CITY OF ALBUQUERQUE

October 26, 2022

Re: Children's Promise Centers LLC
401 Alvarado Dr. SE
Traffic Circulation Layout
Architect's Stamp 08-04-22 (K18-D022)

Based upon the information provided in your submittal received 10-13-22, the above referenced plan cannot be approved for Building Permit until the following comments are addressed:

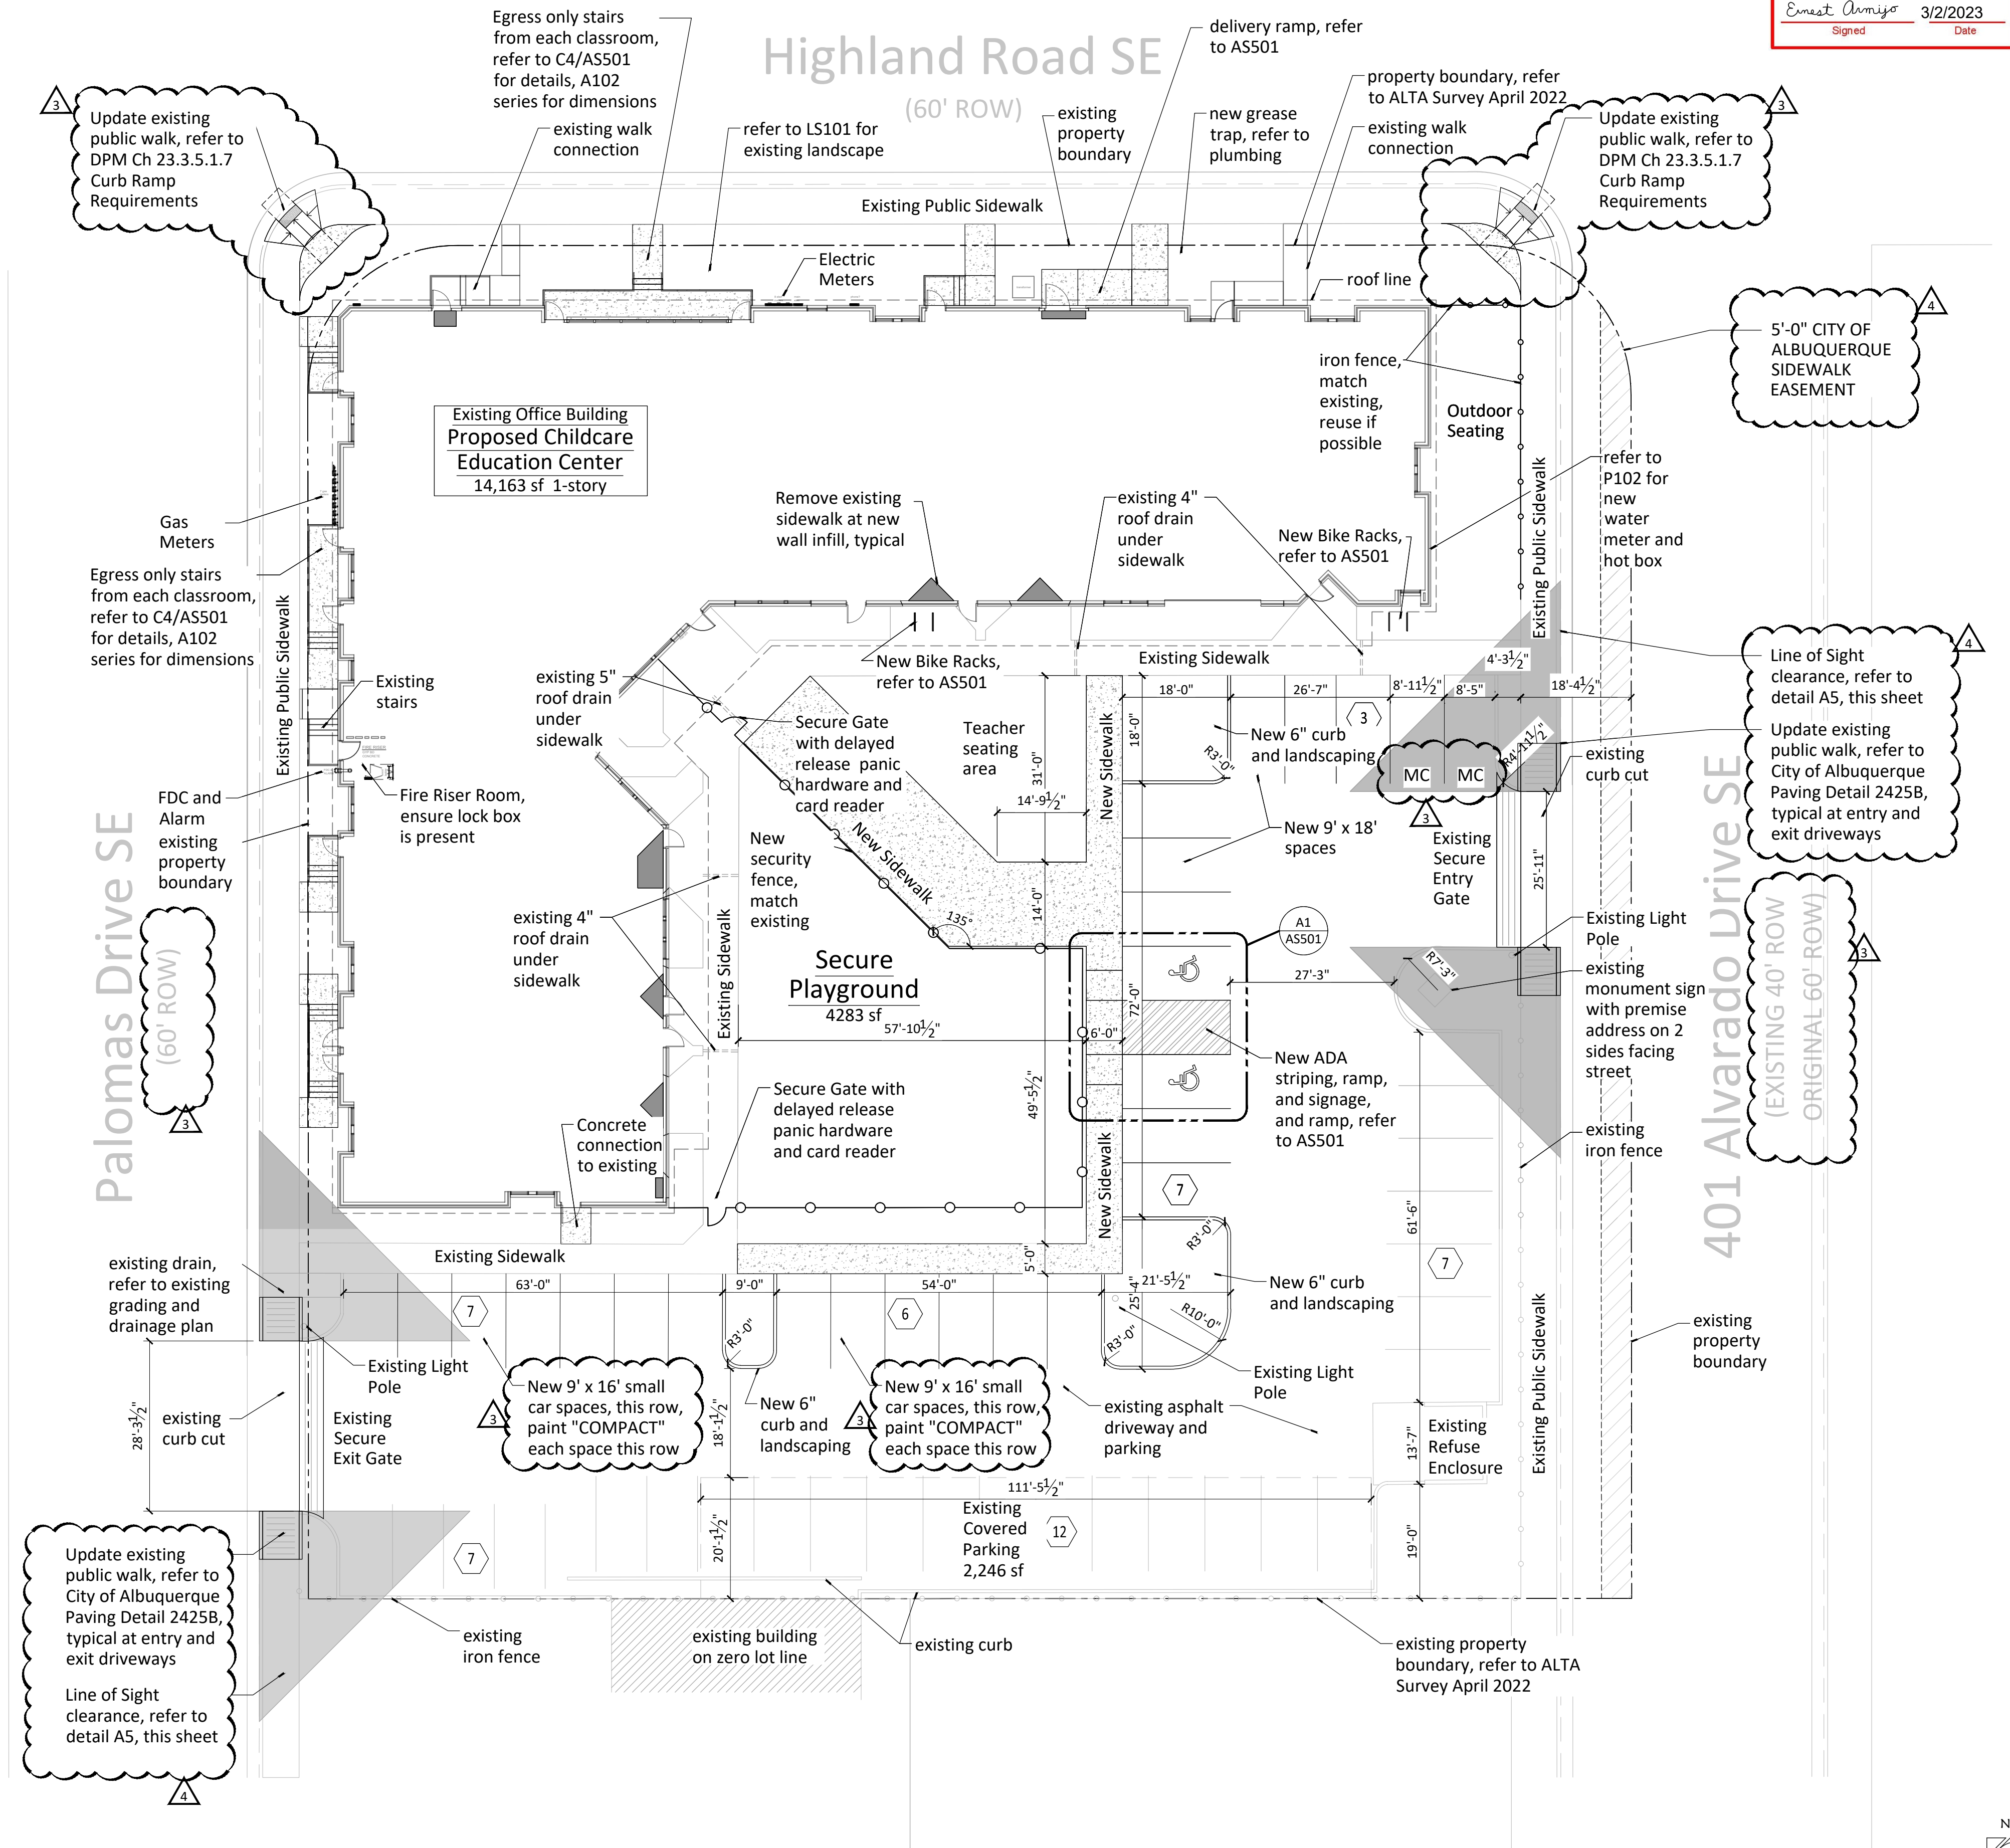
1. Identify the right of way width, medians, curb cuts, and street widths on Alvarado Dr., Highland Rd., and Palomas Dr. SE.
2. Clarify existing property lines and proposed property lines.

3. Site accesses: Driveway accesses off Alvarado Dr., and Palomas Dr. should Curb Return Design with minimum 20 ft. radii.
4. Due to proposing gates, please provide Vehicle Turning Template.

5. Label the compact parking spaces by placing the words "**COMPACT**" on the pavement of each space.
6. ADA curb ramp at the corner of Alvarado dr. and Highland rd. must be updated to current standards and have truncated domes installed.

7. ADA curb ramp at the corner of Highland rd. and Palomas dr. must be updated to current standards and have truncated domes installed.
8. The pavement marking "MC" should be shown in the opposite direction for motorcycles entering the parking space.

9. Per the IDO, a 6 ft. wide ADA accessible pedestrian pathway is required from the public sidewalk to the building entrances. Please clearly show this pathway and provide details.

10. All sidewalks along streets should be placed at the property line.
11. Curbing should be installed to delineate landscape, parking, and pedestrian ways and identify points of access. Please call out detail and location of barrier curb.

12. Refuse vehicle maneuvering shall be contained on-site. The refuse vehicle shall not back into the public right of way.; provide a copy of refuse approval.

14. It is not apparent what type of pavement surface is being proposed. A hard driving surface will be required as part of this proposed project for parking area and drive aisles.

15. Show the clear sight triangle and add the following note to the plan: "Landscaping and signage will not interfere with clear sight requirements. Therefore, signs, walls, trees, and shrubbery between 3 and 8 feet tall (as measured from the gutter pan) will not be acceptable in the clear sight triangle.

16. Please specify the City Standard Drawing Number when applicable.
17. Add a note stating "All broken or cracked sidewalk must be replaced with sidewalk and curb & gutter." A build note must be provided referring to the appropriate City Standard drawing.
